# CITY OF ALBUQUERQUE

**RE:** Mesa Cold Storage Repave Project  
Grading and Drainage Plan  
Engineer's Stamp Date 2-7-2017 (Fil: H13D108)

Based upon the information provided in your submittal received 2-8-2017, the above referenced Grading and Drainage Plan cannot be approved for paving permit until the following comments are addressed:

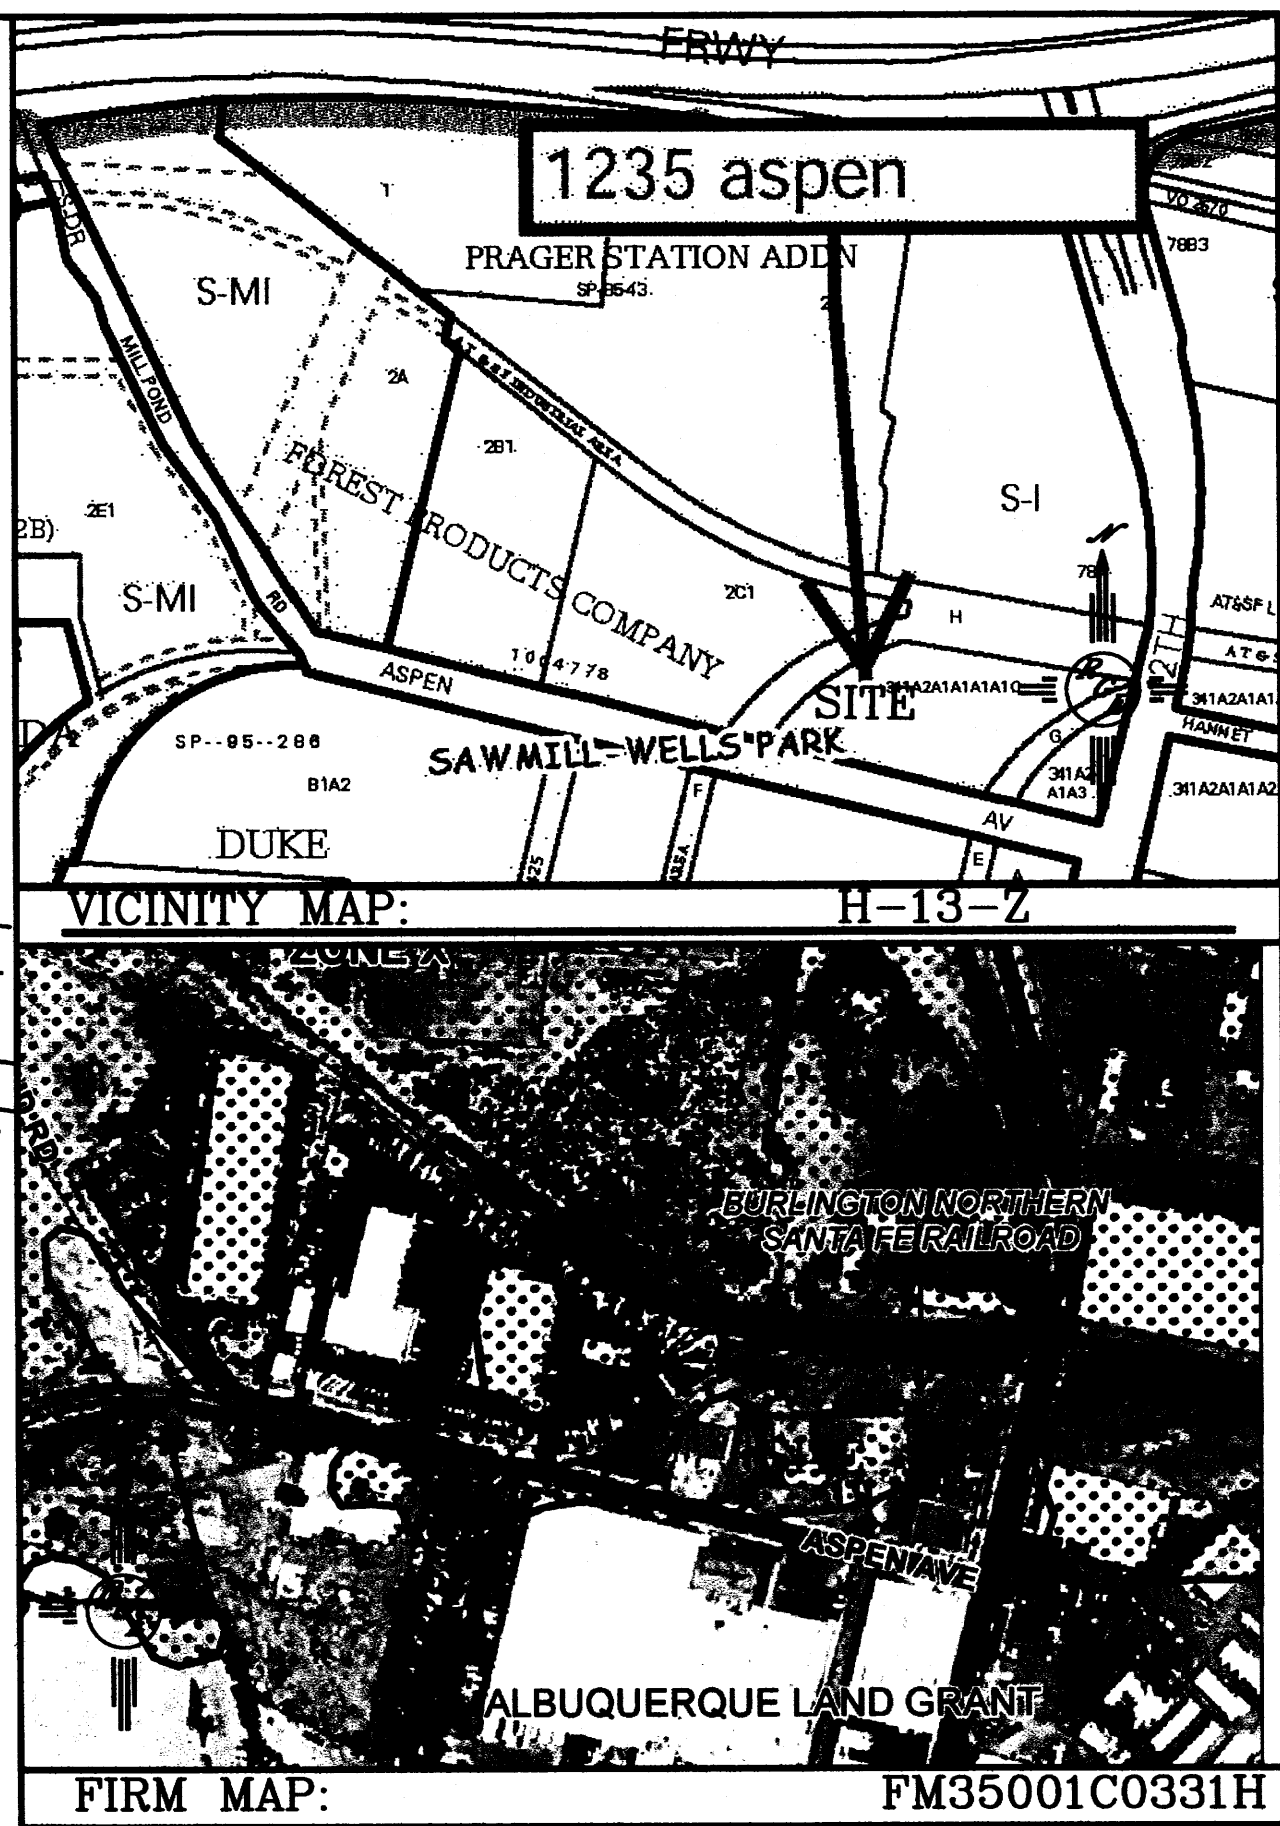
1. Provide onsite and offsite flow narrative.
2. It's not clear if the proposed grade tie to the existing grade.
3. Existing driveway must meet ADA requirement. The area between sidewalk and property line is consider part of the drive way.
4. Show flow line elevation by the driveway. Do we adequate water block?
5. Fix the text overlaps.
6. Parking restriping and handicap parking signage must be coordinated with transportation.
